Date: 13 June 2025  
Our ref: 17503; 489461  
Your ref: EN010125  
Interested Party ref: 20050173

**Application by RWE Renewables UK Dogger Bank South (West) Ltd and RWE Renewables UK Dogger Bank South (East) Ltd for an Order granting Development Consent for the Dogger Bank South Offshore Wind Farms**

The following constitutes Natural England's formal statutory response for Examination Deadline 6.

**Figure 5-1 Changes to bed shear stress due to tidal wake effects at DBS (modelling presented in Appendix 8.3 Marine Physical Processes Modelling Technical Report [AS-135])**

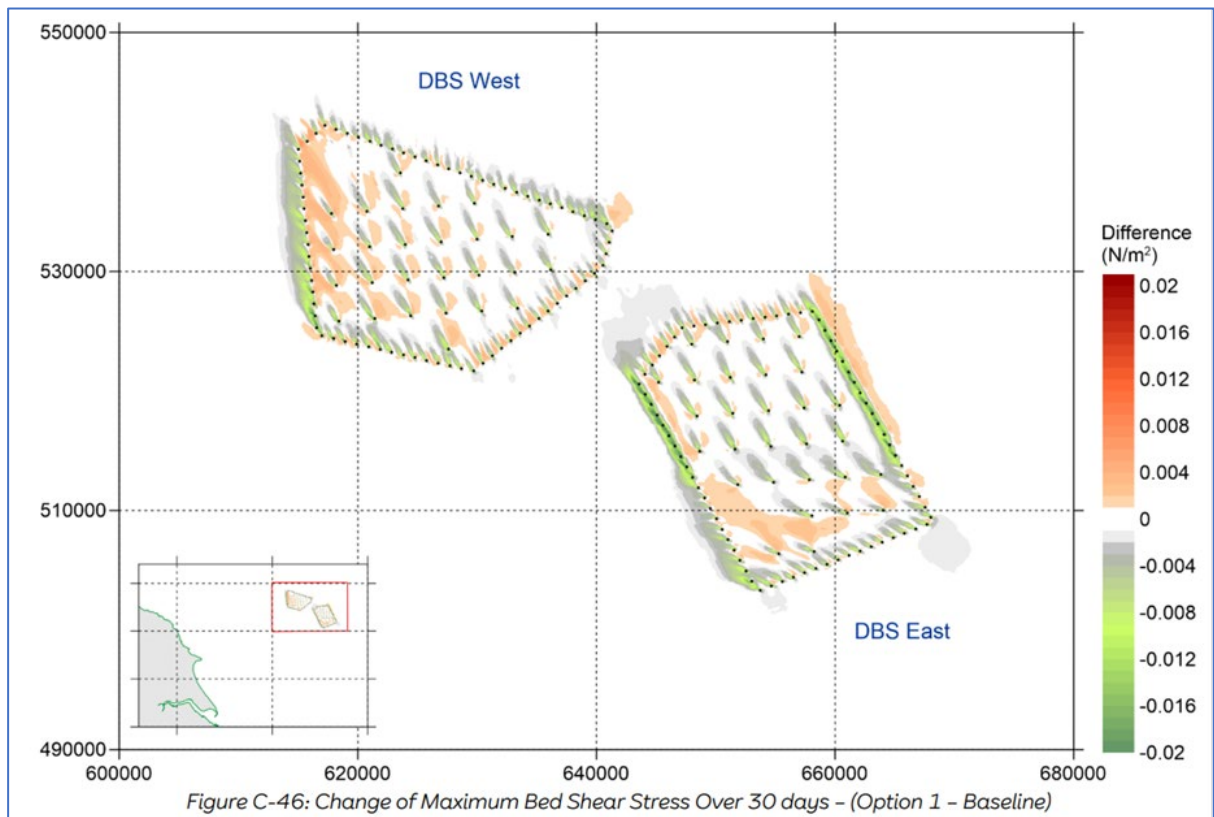
Natural England welcome the Applicant’s provision of “15.7 Ecological Halo Effects Technical Note” [REP5-041]. We agree that, based on currently available evidence, 50m is an appropriate buffer to use to assess the potential area of impact. However, we disagree with the exclusion of ecological halo effects surrounding cable protection from the Applicant’s estimate. We also disagree that it is appropriate for the predicted impact area to be reduced by 75% based on wake/bed shear stress effects. We therefore advise that a revised estimate should be provided based on the full impact area with the inclusion of cable protection.

Figure: 4-4 Drawing No: PC2340-RHD-OF-ZZ-DR-Z-1038

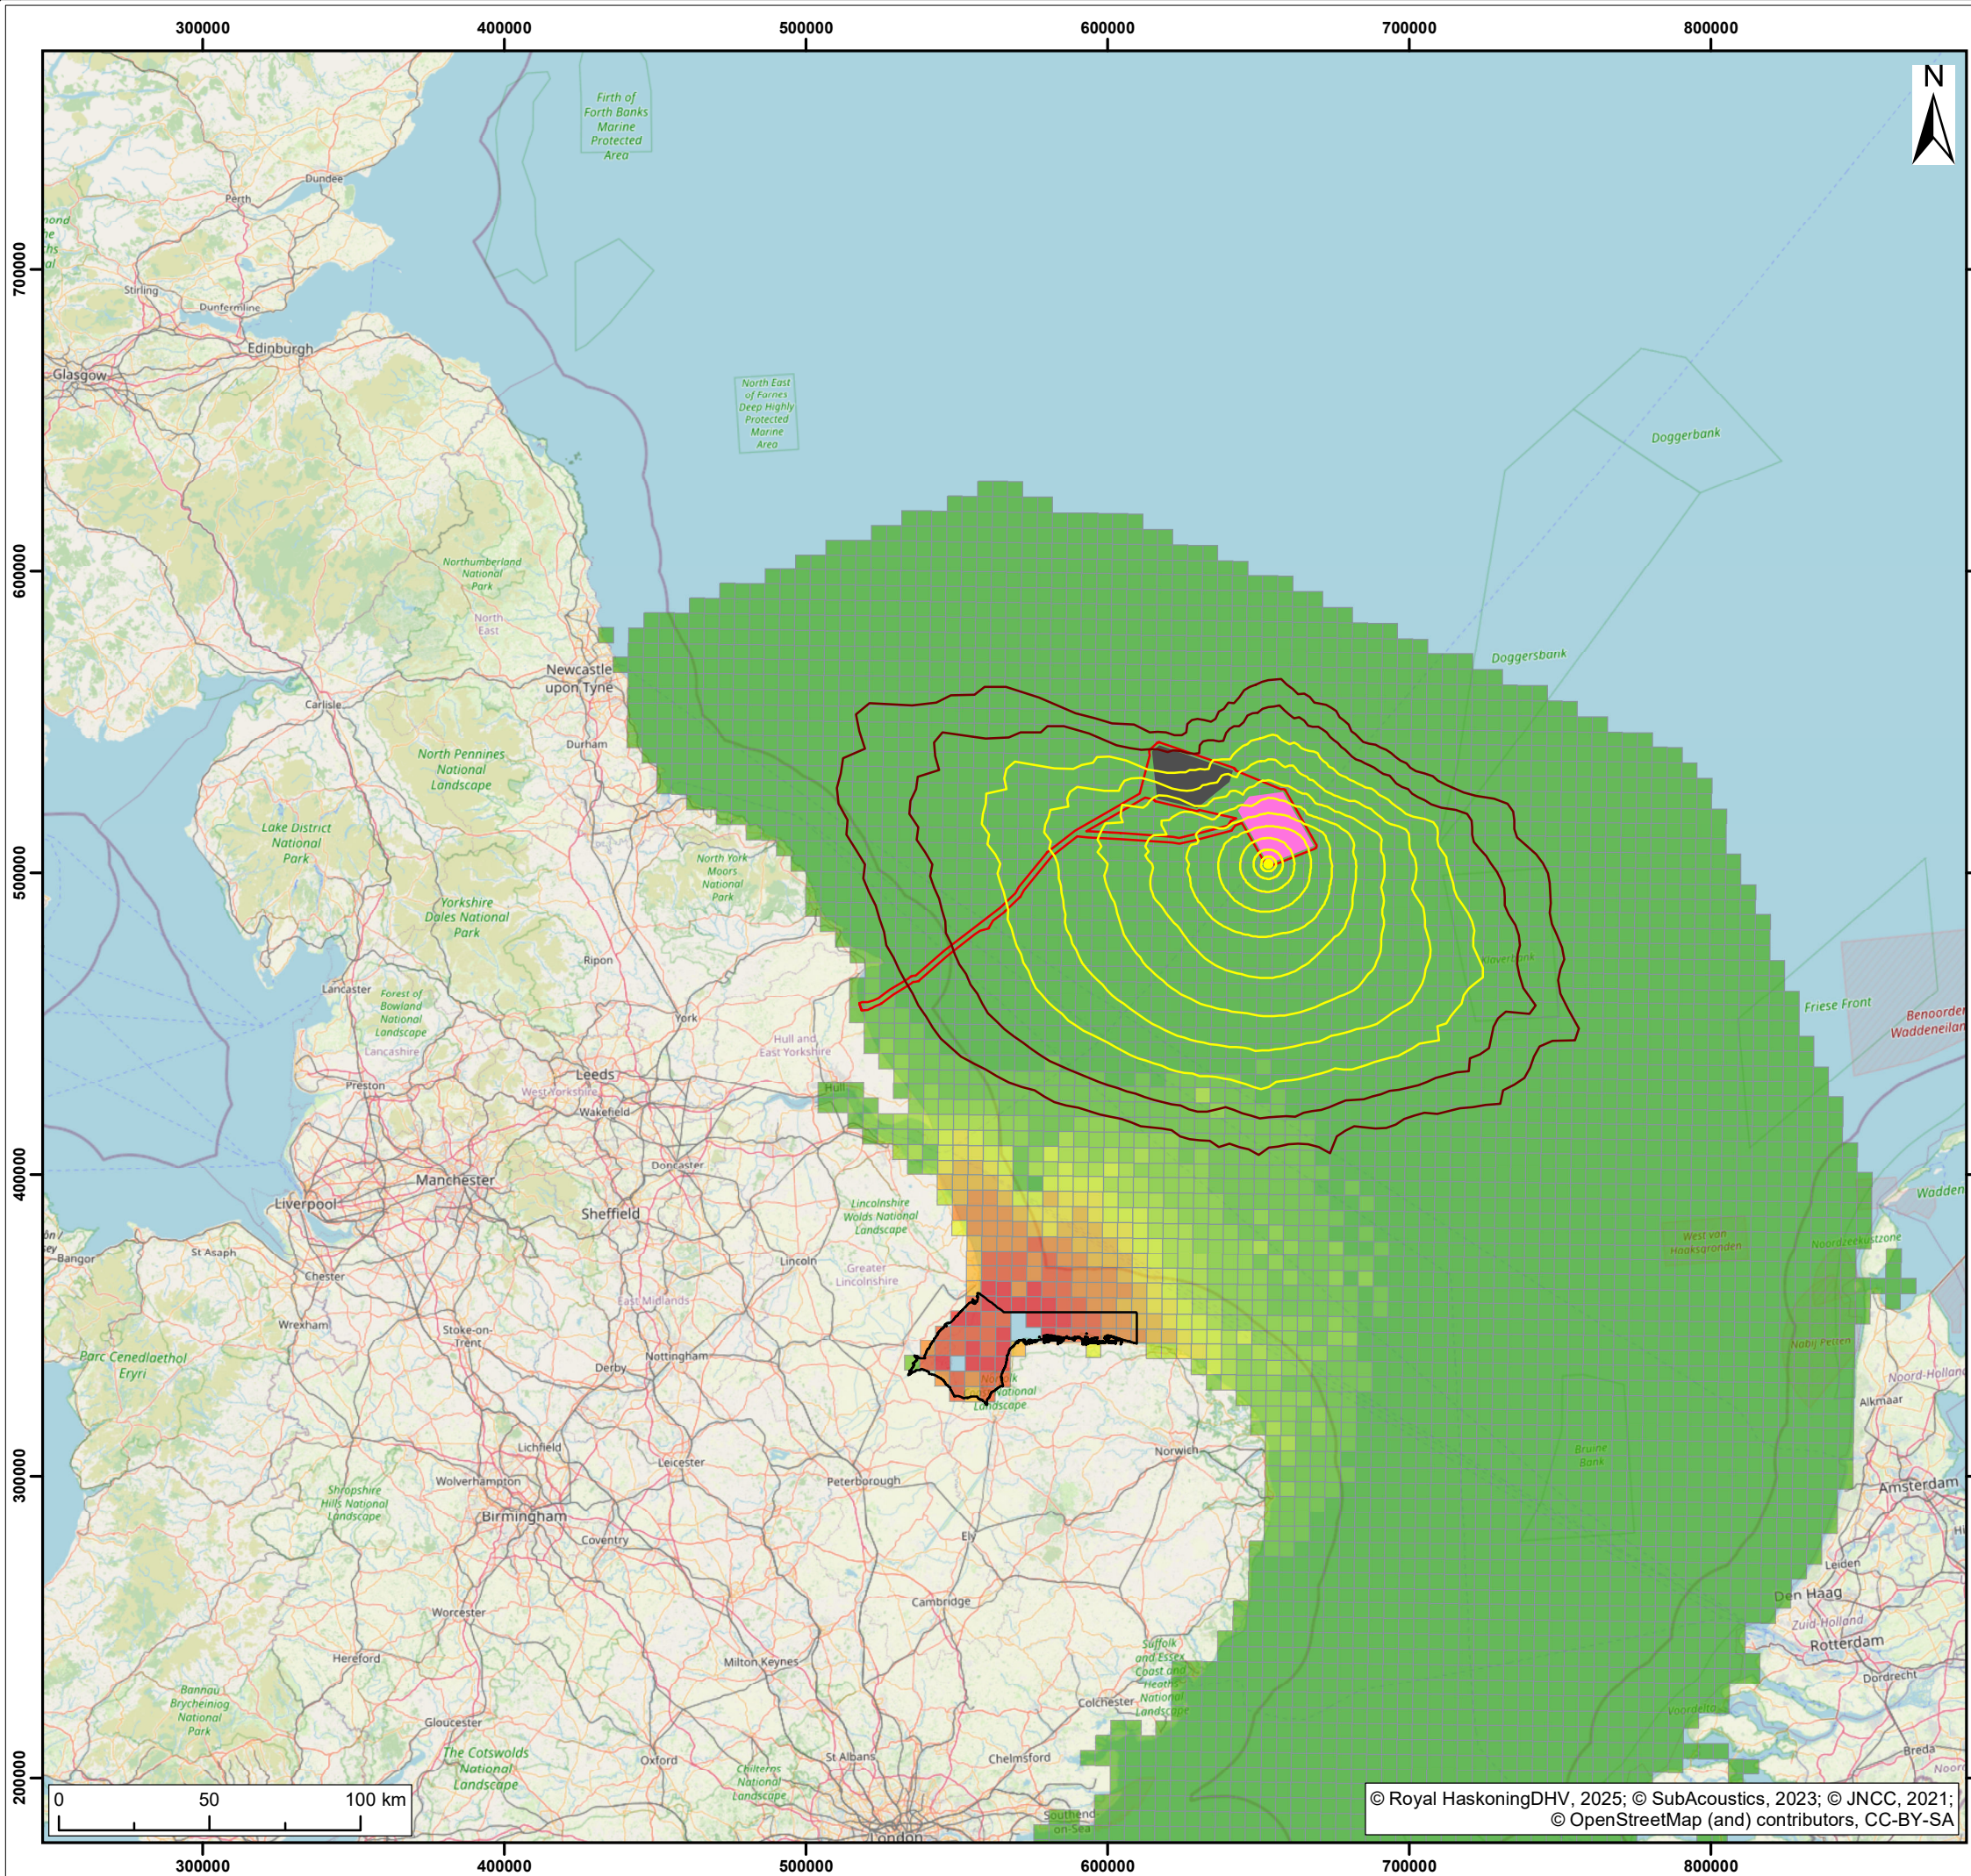
Based on the updates to the Applicant’s RIAA [REP5-010], an Adverse Effect on Integrity cannot be ruled out for harbour seal in the Wash and North Norfolk Coast SAC. We advise that confirmation is needed on whether the updated values presented in [REP5-010] are correct, and if so, that an explanation for the increased impact is provided. If the assessment

is correct, we consider it likely that a commitment to deliver a 10 dB reduction in underwater noise from construction activities would reduce impacts to a level to remove adverse effects, however this would need to be demonstrated.
